Date: 19th October 2020

Our Ref: BN/93/20/DOC

Approval of details reserved by condition imposed under ref BN/130/19/HH relating to Condition No 3 - surface water drainage.

Flamsteed Lake Lane Barnham PO22 0AD

Proposed Ground Floor

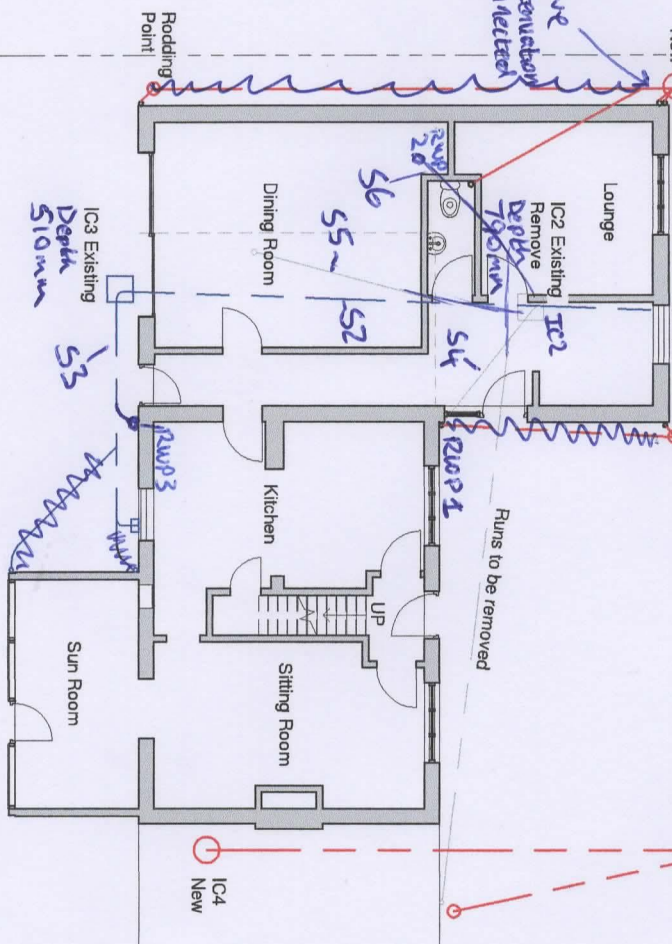
3. To satisfy the condition, the plans need to be much more detailed including the provision of construction detail drawings for the various elements. The layout plan needs to include all pipe diameters/gradients, manhole cover and invert levels, storage tank levels, etc.

5. Detailed construction drawings for the surface water drainage need to include manholes, rodding eyes, details of arrangements where the pipe passes under the extension (ie. IC3 to IC6) /through foundations, pipe bedding, gullies, storage tank (including connections and outlet arrangements) and flow control details. As the flow control device will probably be of a small scale, the design will need to consider measures to reduce the risk of blockage. Please note the preference would be for pipe run IC3 to IC6 to be routed around the building if possible.
